Closure of the U6006 – Applicants response

PRoW REP6-069 John Leitch

Drawing Title
**FIGURE 3-1
SUNNICA EAST
PARAMETER PLAN**

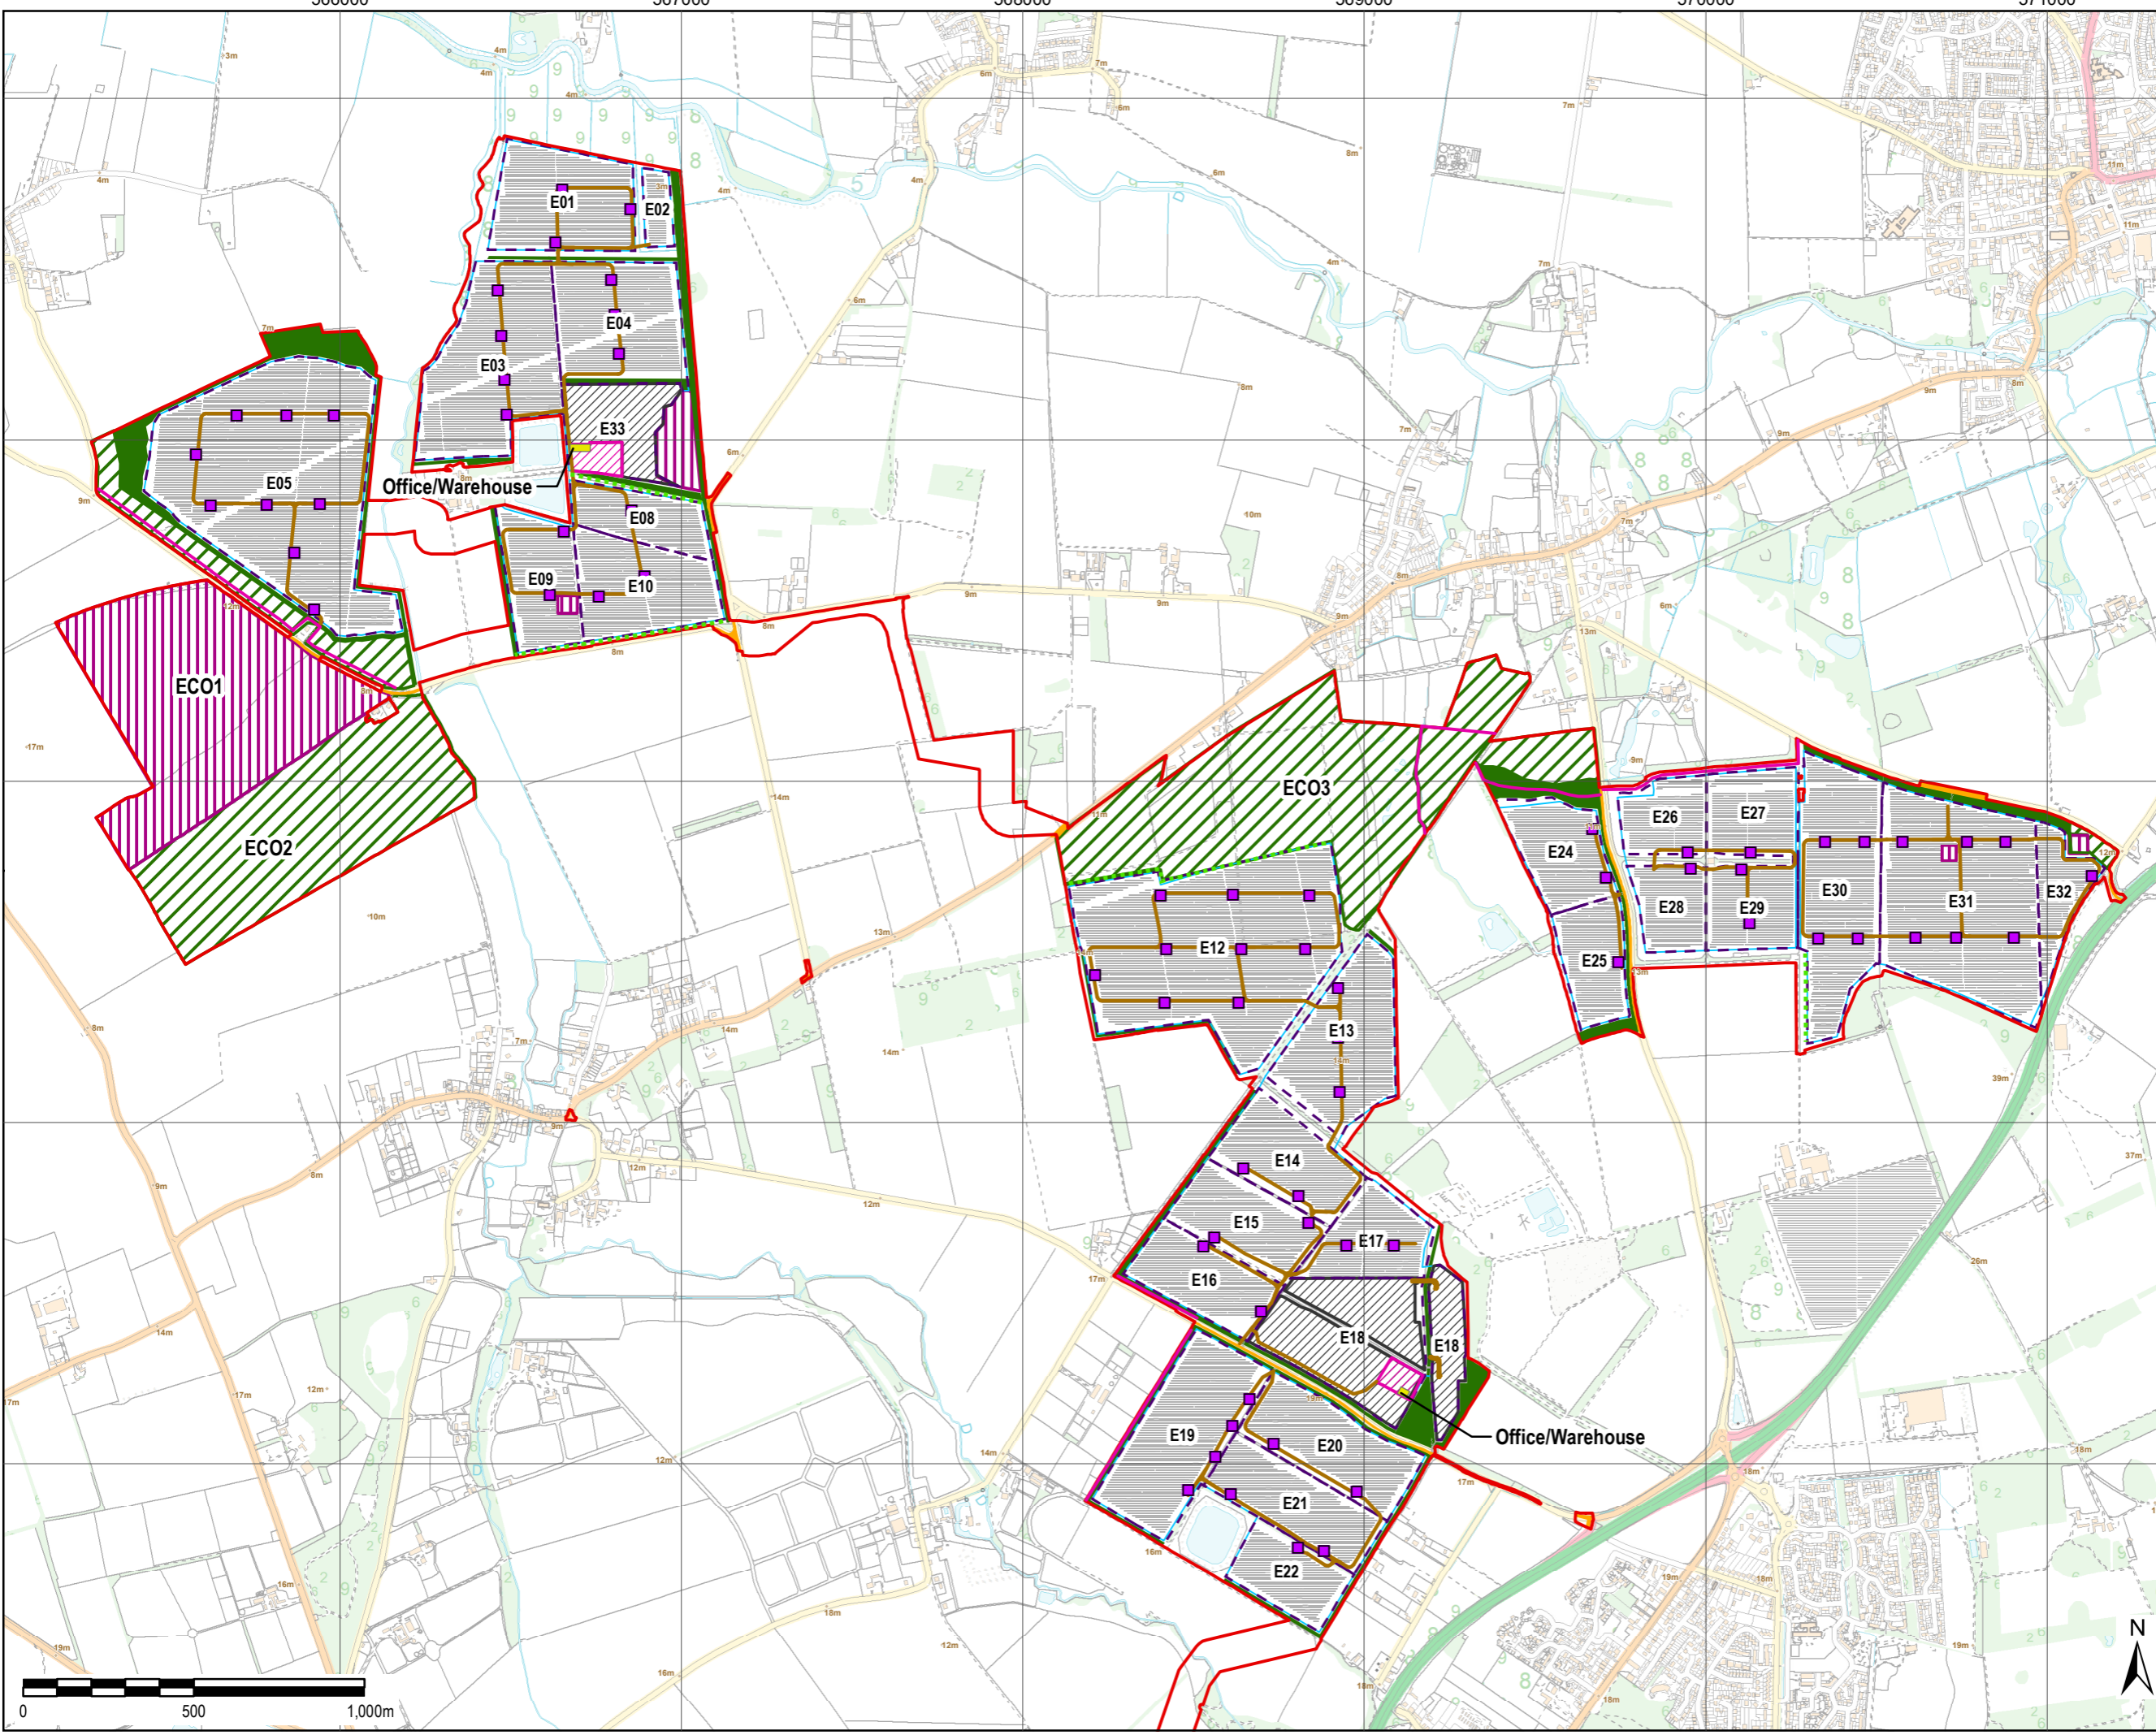
Please explain the significance of “14m” in E13 of the map figure 3-1 Sunnica East Parameter Plan 60589004 and why this is unique to E13?
